Our ref: DOC21/942110-1

Your ref: SSD 12469087

Gunlake Quarry Continuation Project (SSD 12469087) – Advice on EIS

We are of the view that the BDAR has several limitations. These are described in detail in **Attachment 1**, but in summary:

Gunlake Quarry Continuation Project
Groundwater assessment
Figure 6.4

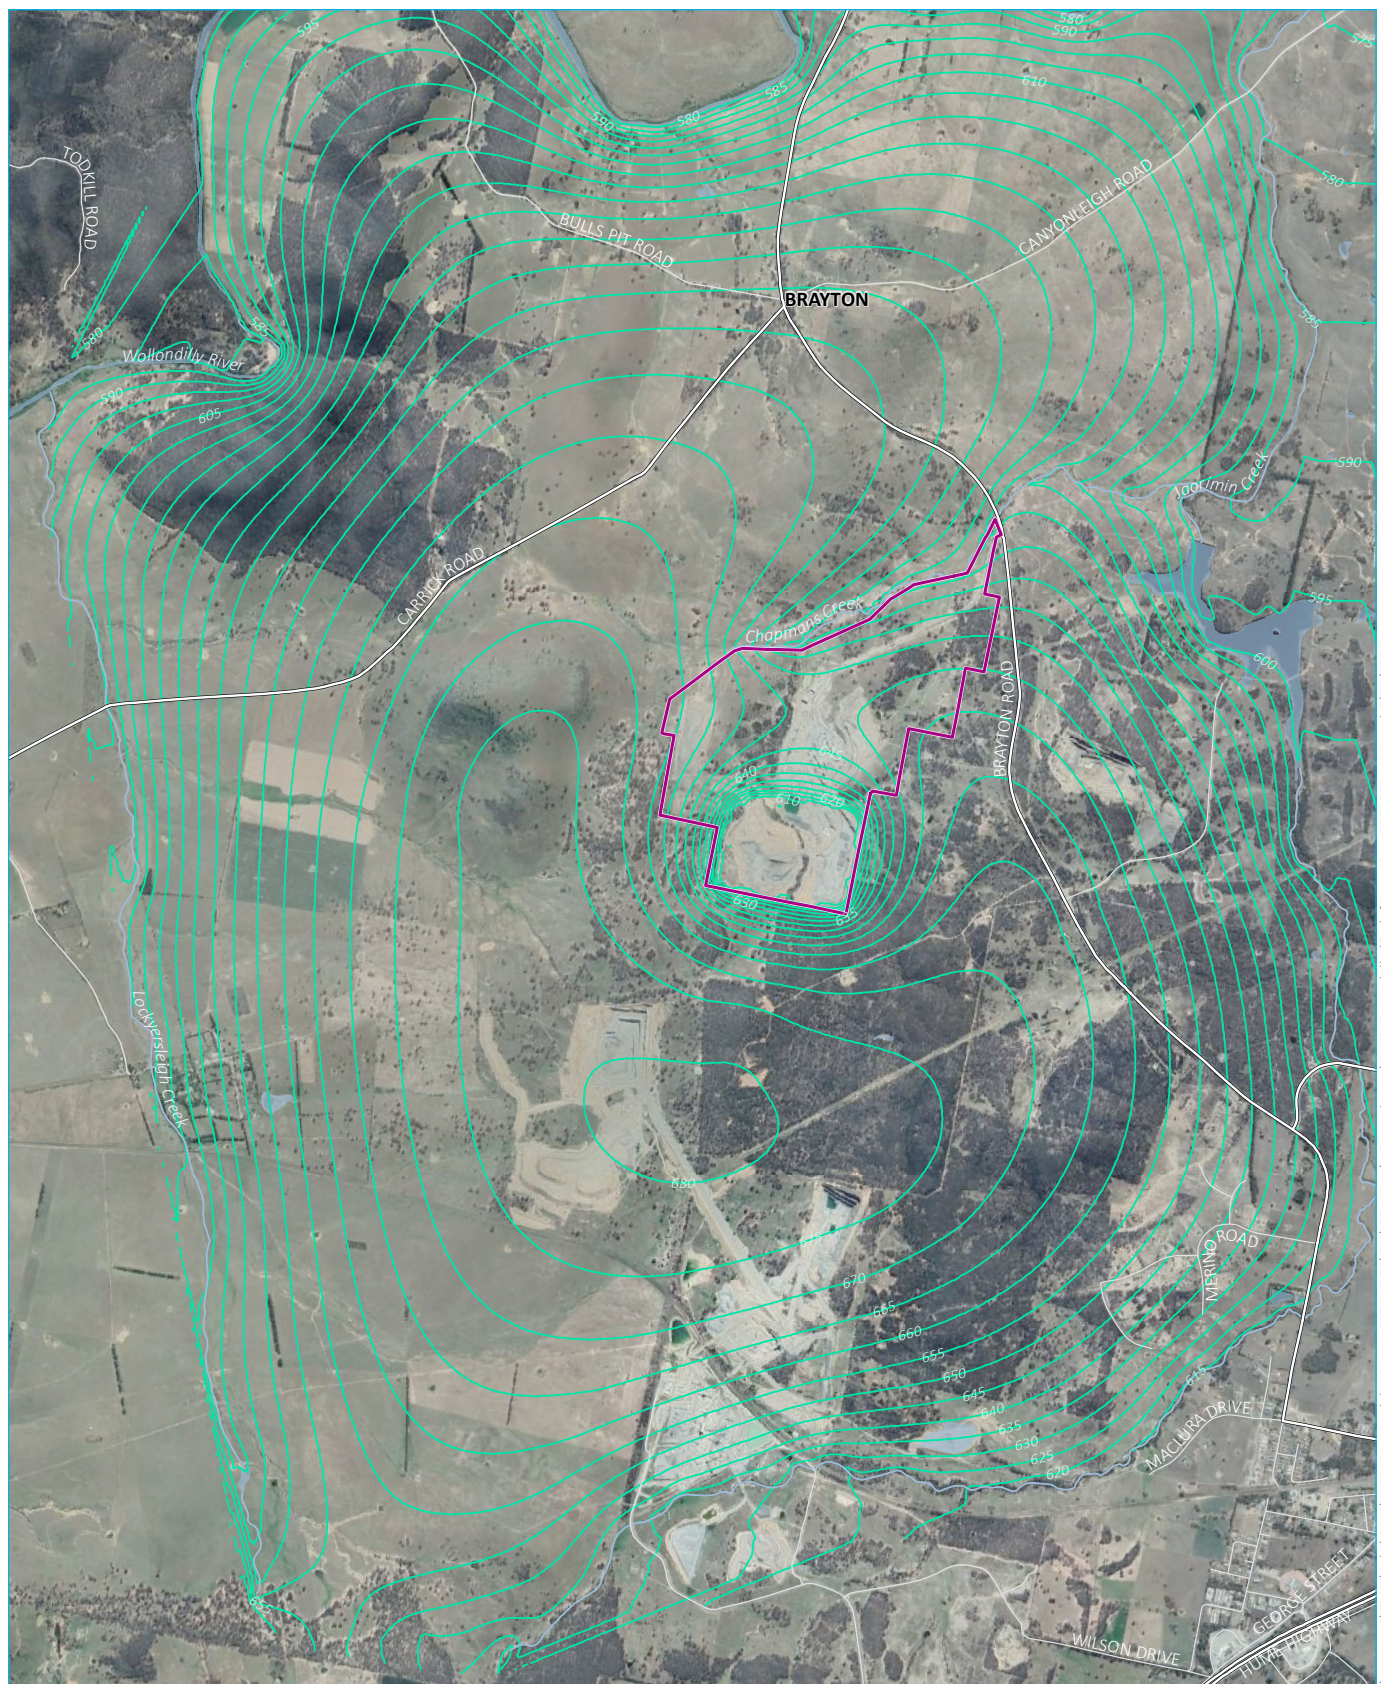
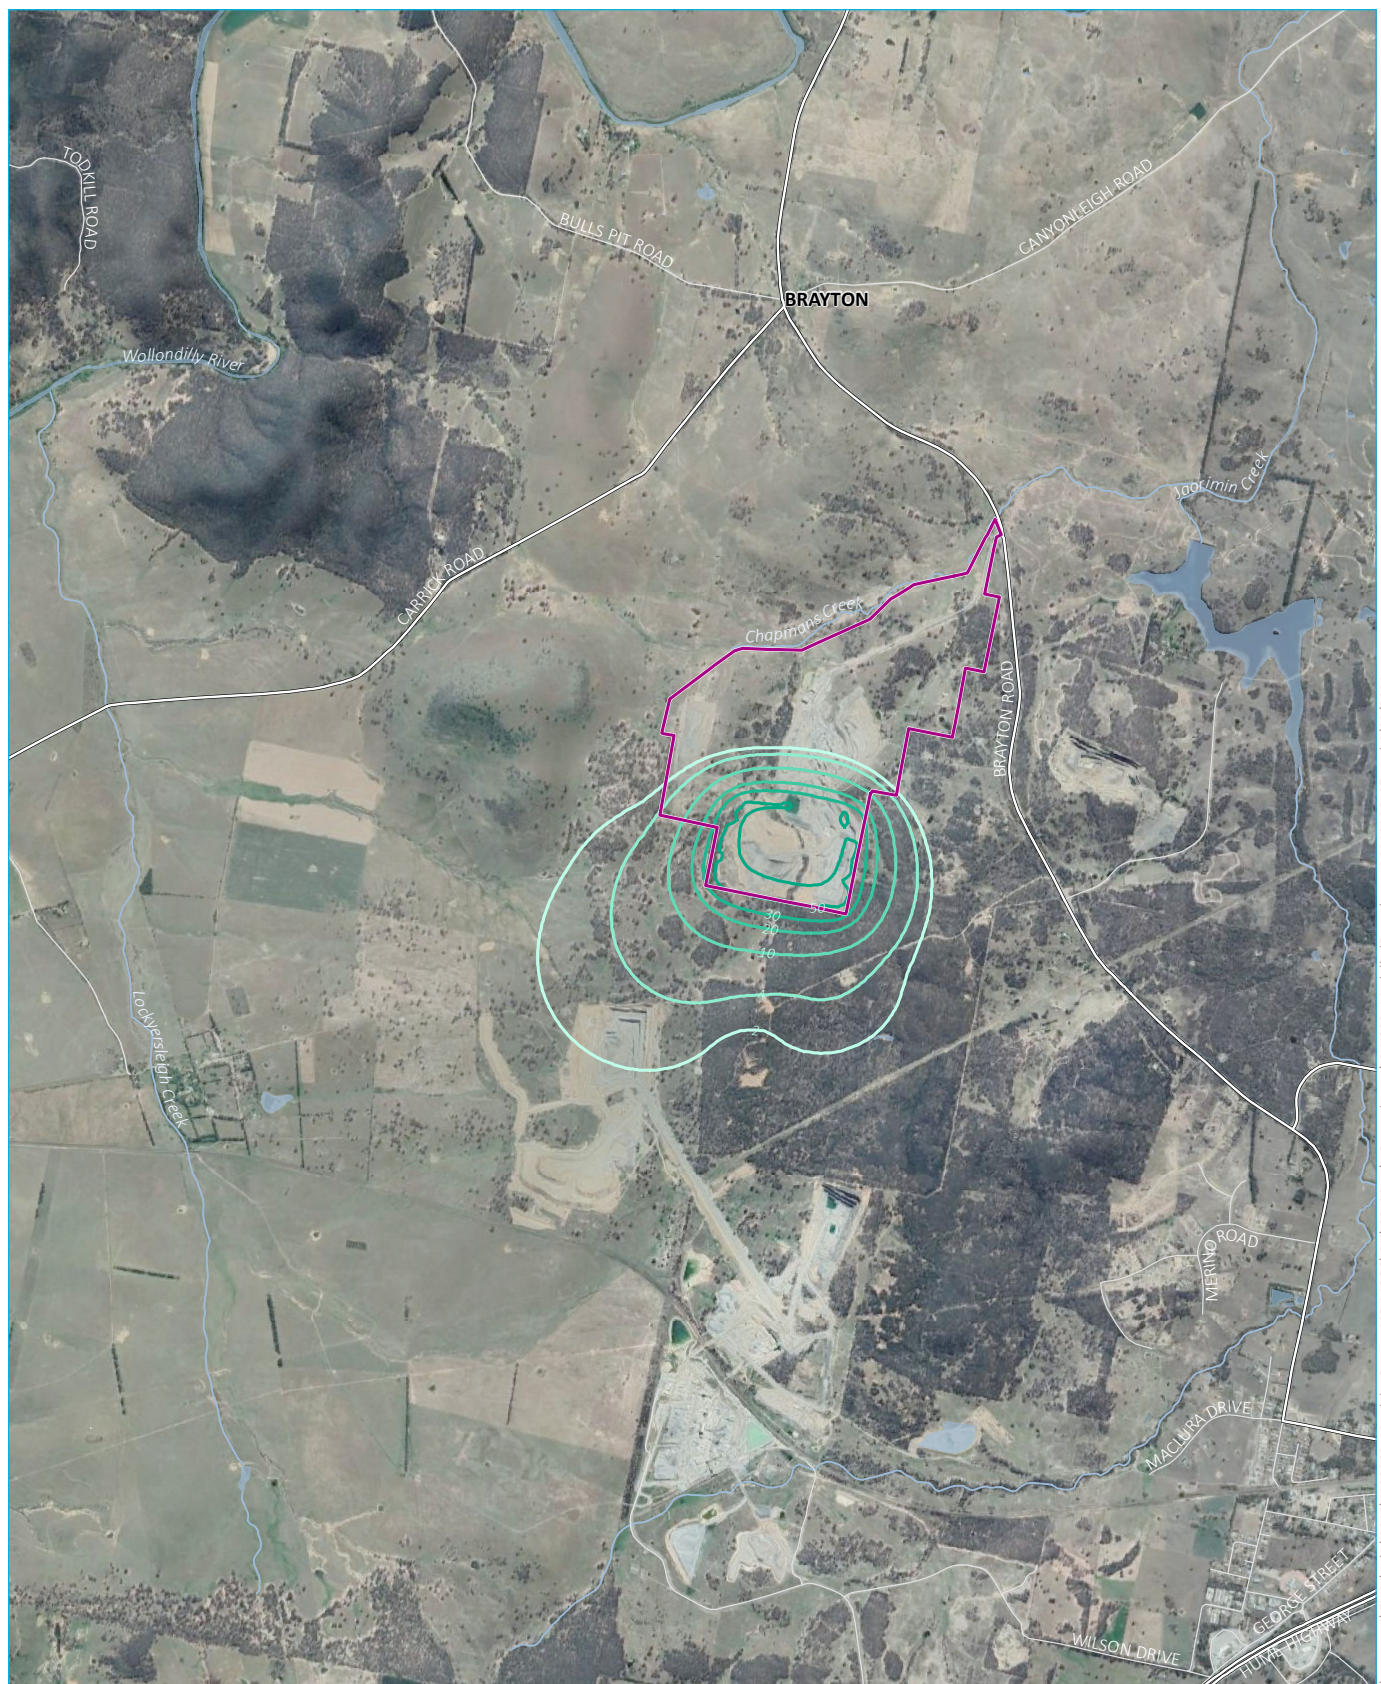
- There is a substantial difference in modelled groundwater heights before the quarry when compared to the groundwater assessment undertaken for the Holcim Lynwood Quarry. Holcim Lynwood Quarry predicted groundwater at a maximum height of ~655m AHD, whereas the Continuation Project predicts groundwater at a maximum height of ~685m AHD.

- Discrepancies between the models needs to be reconciled to demonstrate that the Continuation Project's Groundwater Assessment is scientifically rigorous and fit for purpose.

The Applicant also needs to further clarify why drawdown is not predicted to occur north of the quarry.
